## REVISION/DEFERRED SUBMITTAL FORM

Site Address 8455 SE 83rd Street

Permit Number 2208-260-SUB-1

Date March 31, 2023  
To City of Mercer Island  
Community Planning & Development  
From Chris Haddad  
Permit Number **2208-260-SUB-1**  
Project Address 8455 SE 38rd Street  
Mercer Island, WA 98040  
Reference **Jaffe Residence - Revisions to a plan currently in review**

**A1.0a**

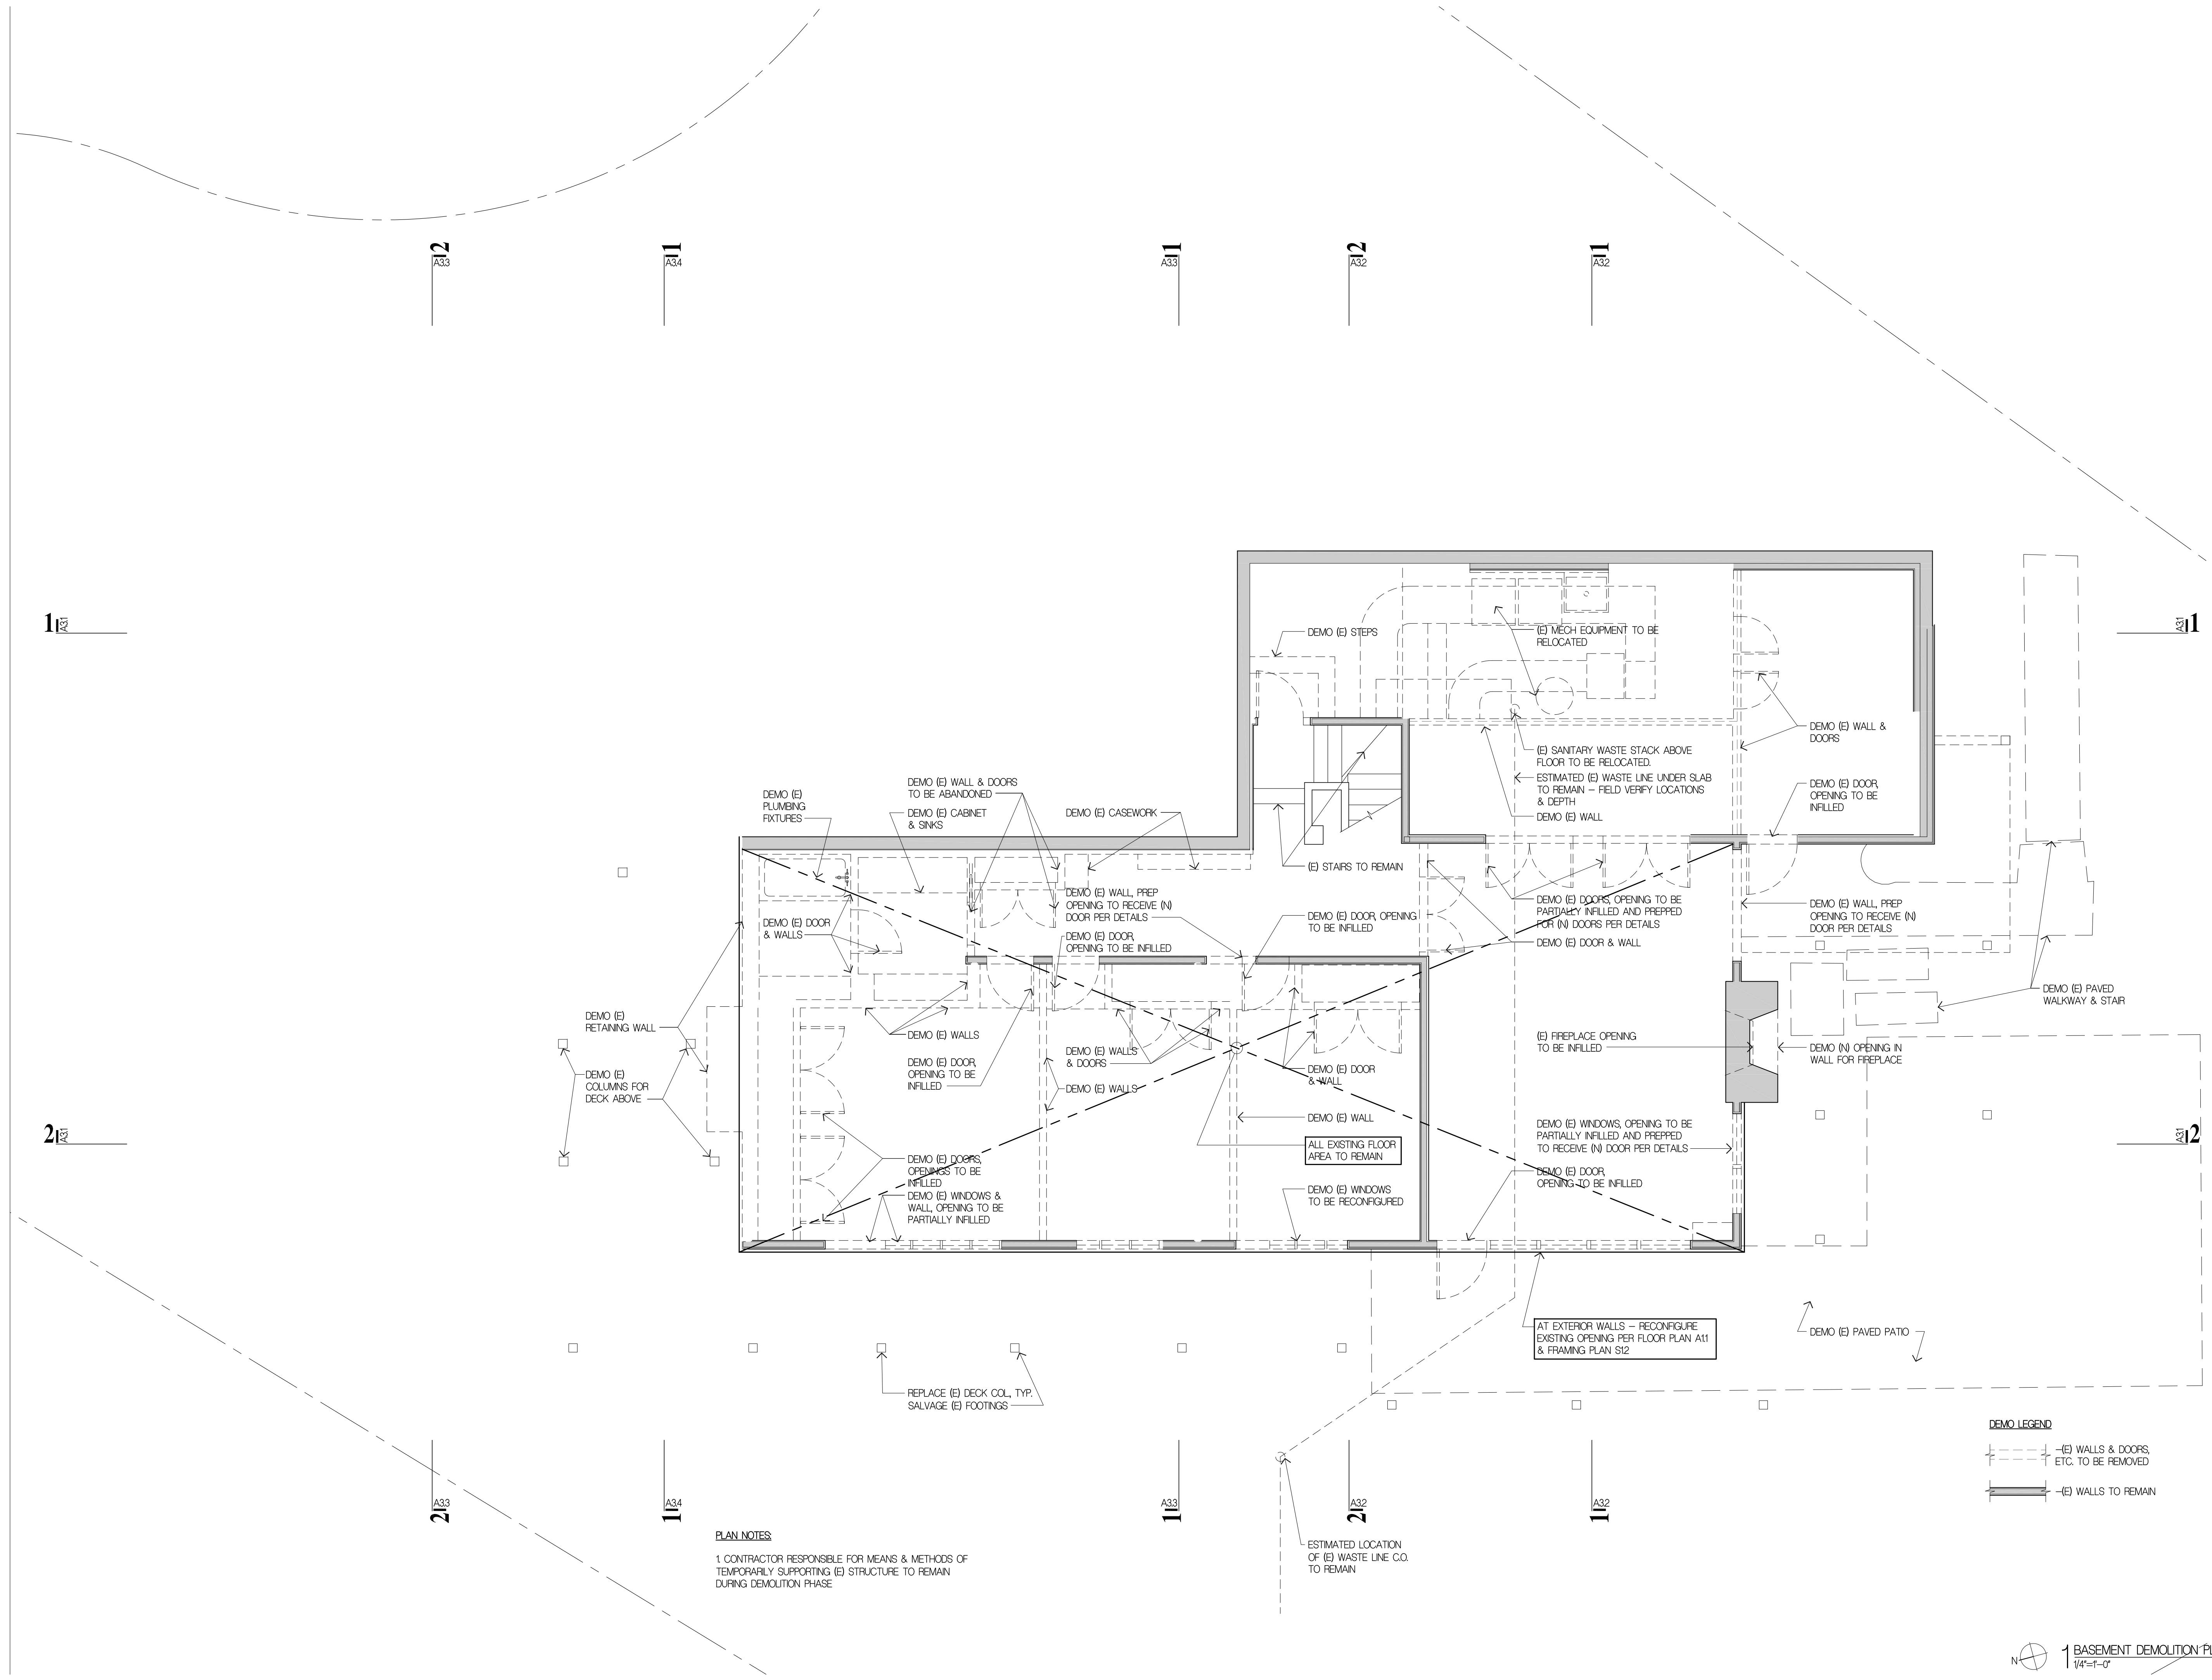
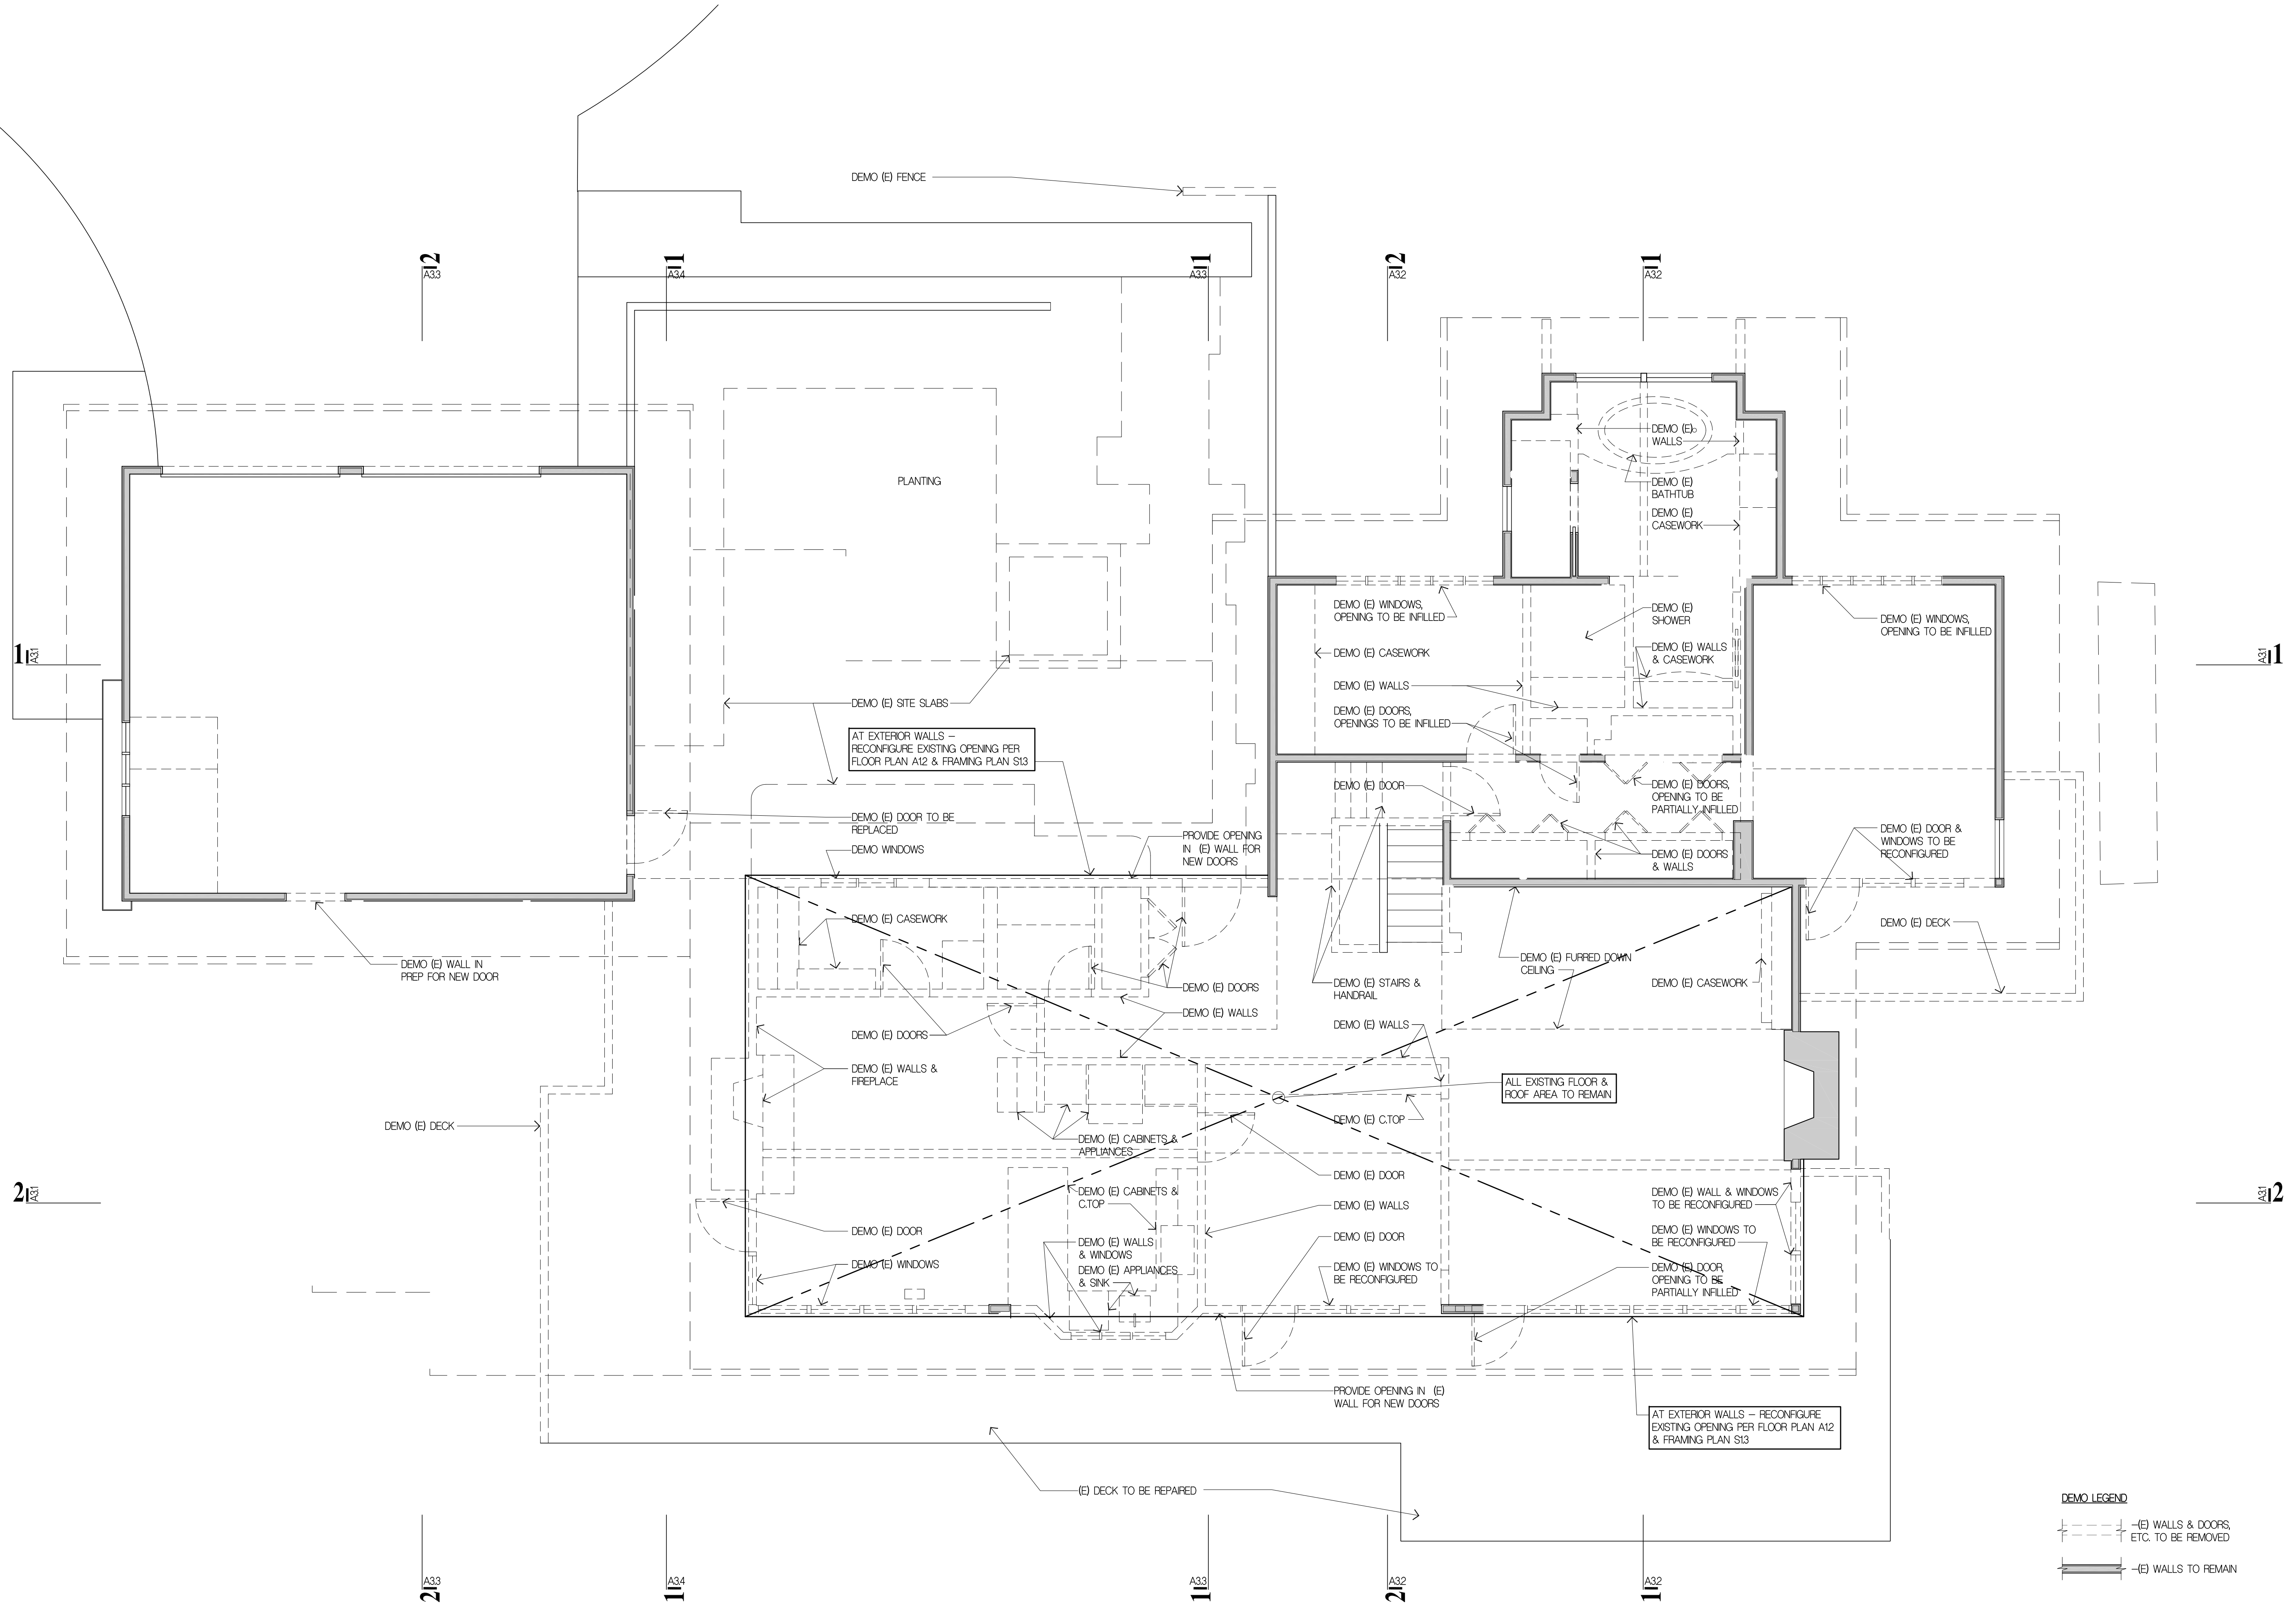
- The plans have been revised to show the reduced scope of work. More walls and doors are to remain as-is.

Date  
 08/08/2022  
 Job No.  
 210

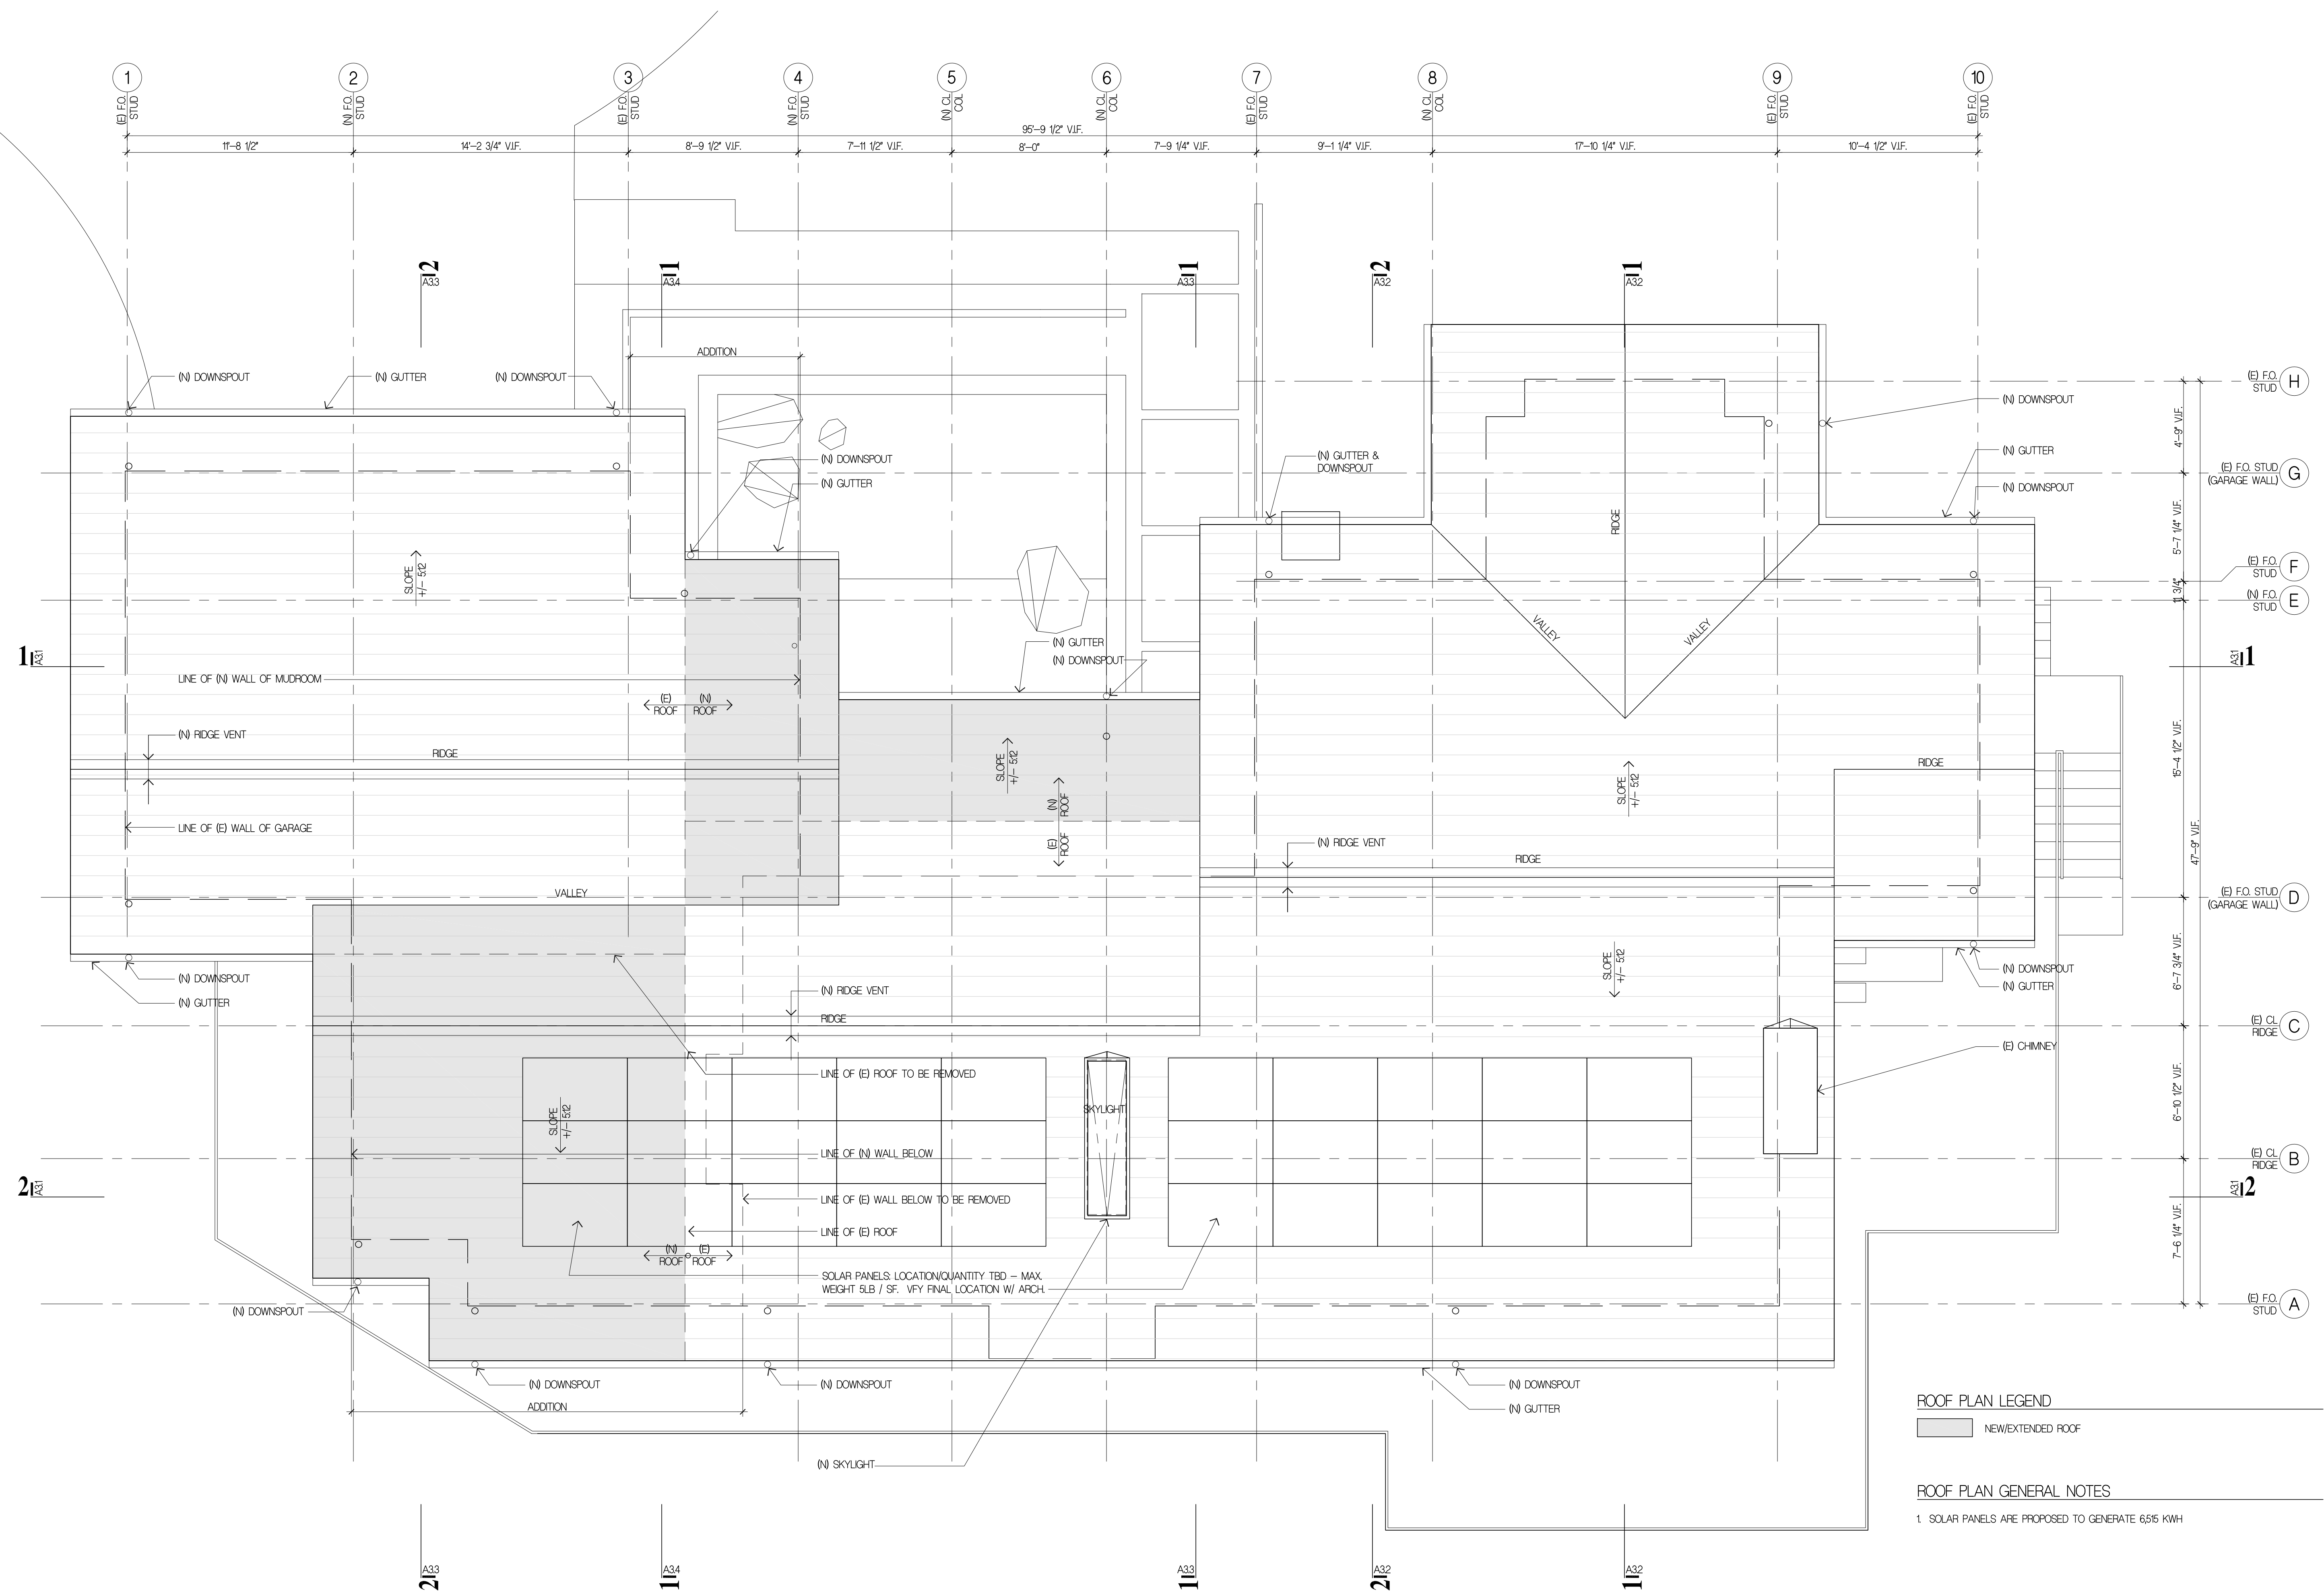
- The solar panels have been eliminated. Refer to the sheet TS-1 for revised energy credit approach.
- The new roofing material has been changed from metal roofing to the composition shingle roofing.
